CITY OF ALBUQUERQUE

Re: Townhouse for Ahmet Tiryaki
910 Chelwood Blvd. N.E. Albuquerque, NM **87112**
Traffic Circulation Layout
Engineer's/Architect's Stamp **10-11-18 (J22D070)**

Based upon the information provided in your submittal received 10-12-18, the above referenced plan cannot be approved for Building Permit until the following comments are addressed:

CIVIL101

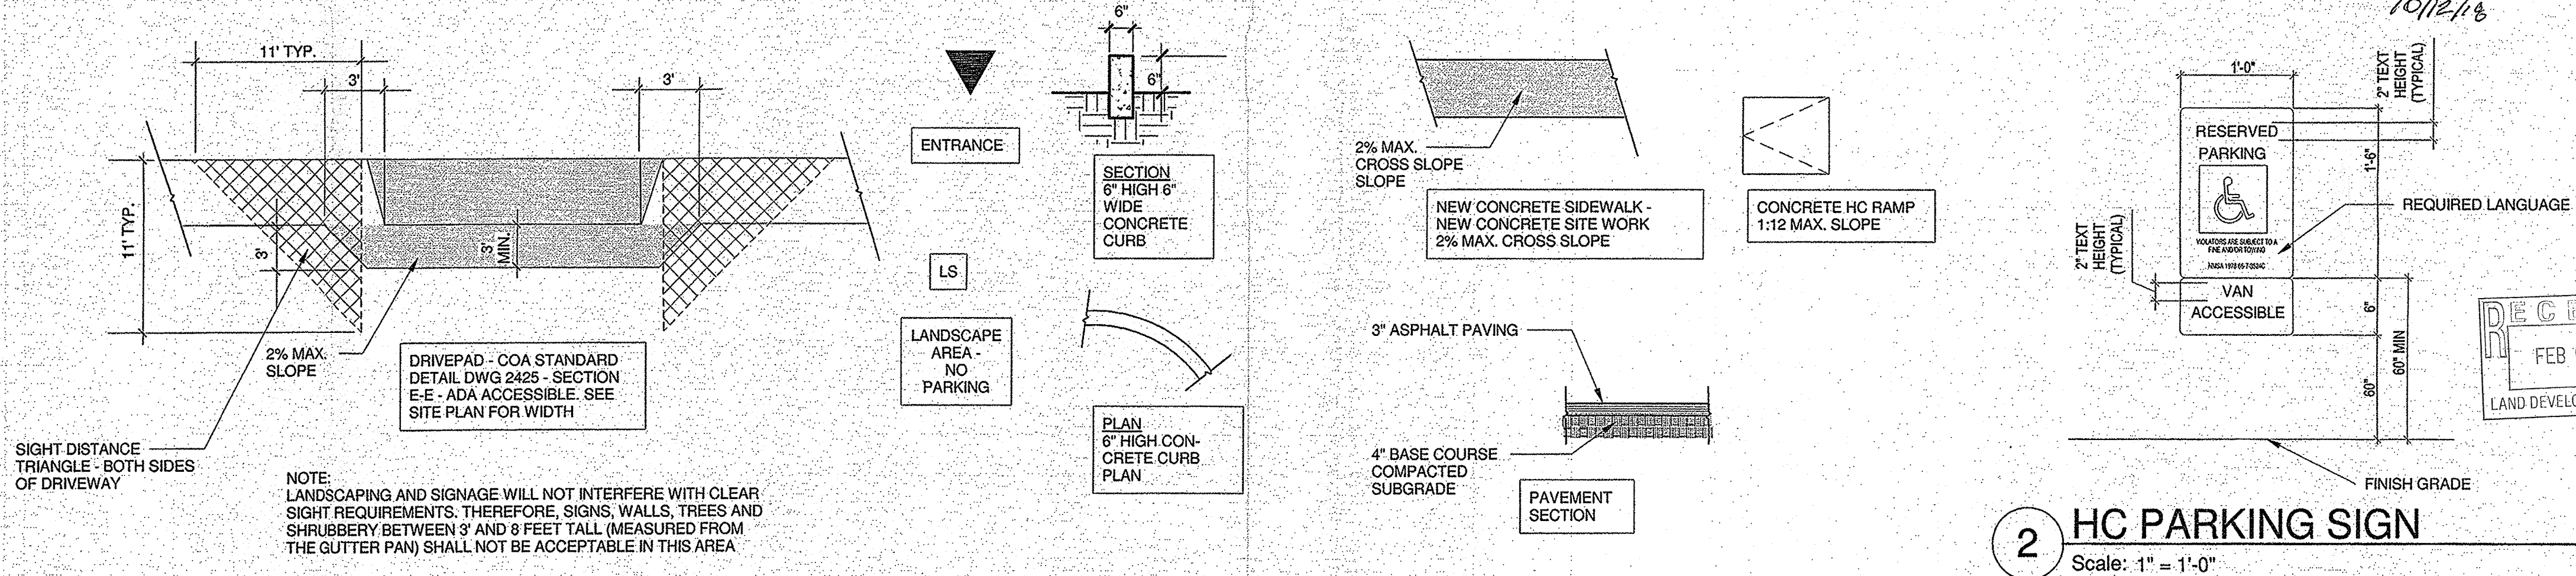
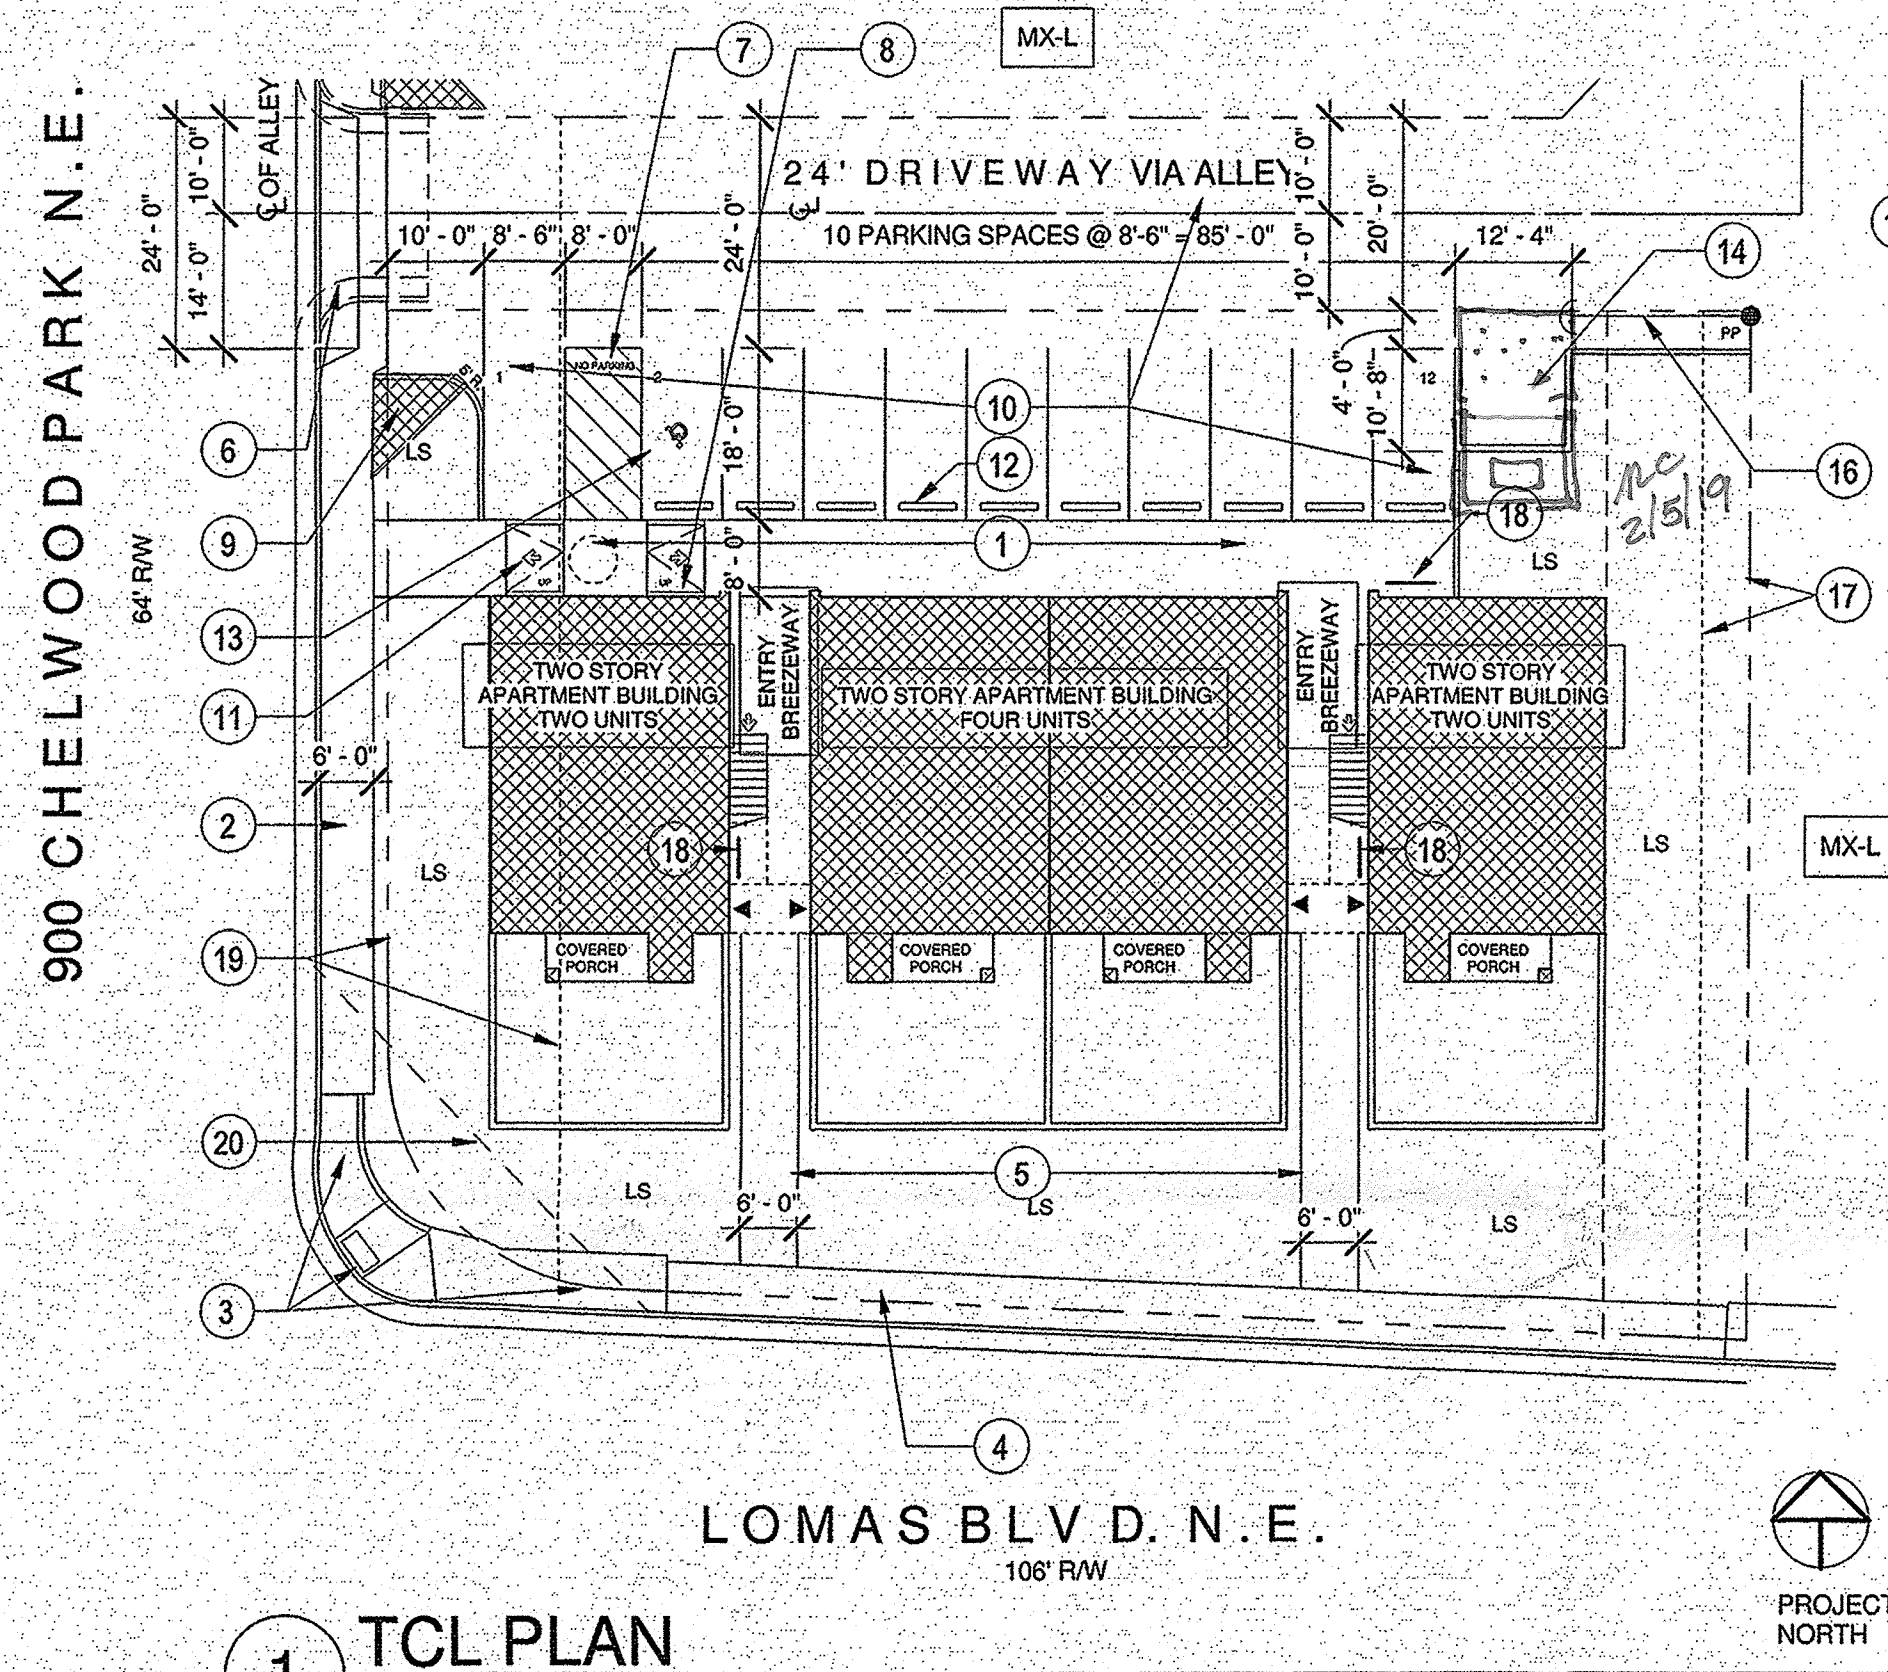
1. Move the refuse container further to the north and provide a concrete surface in front of the refuse tank.
2. A work order for the sidewalk on all public properties should be submitted before TCL approval. (Chelwood park and Alice Ave and Alley pavement)
3. Please add a note on the plan stating "All improvements located in the Right of Way must be included on the work order."
4. The certificate of Occupancy will be held for work order close out.
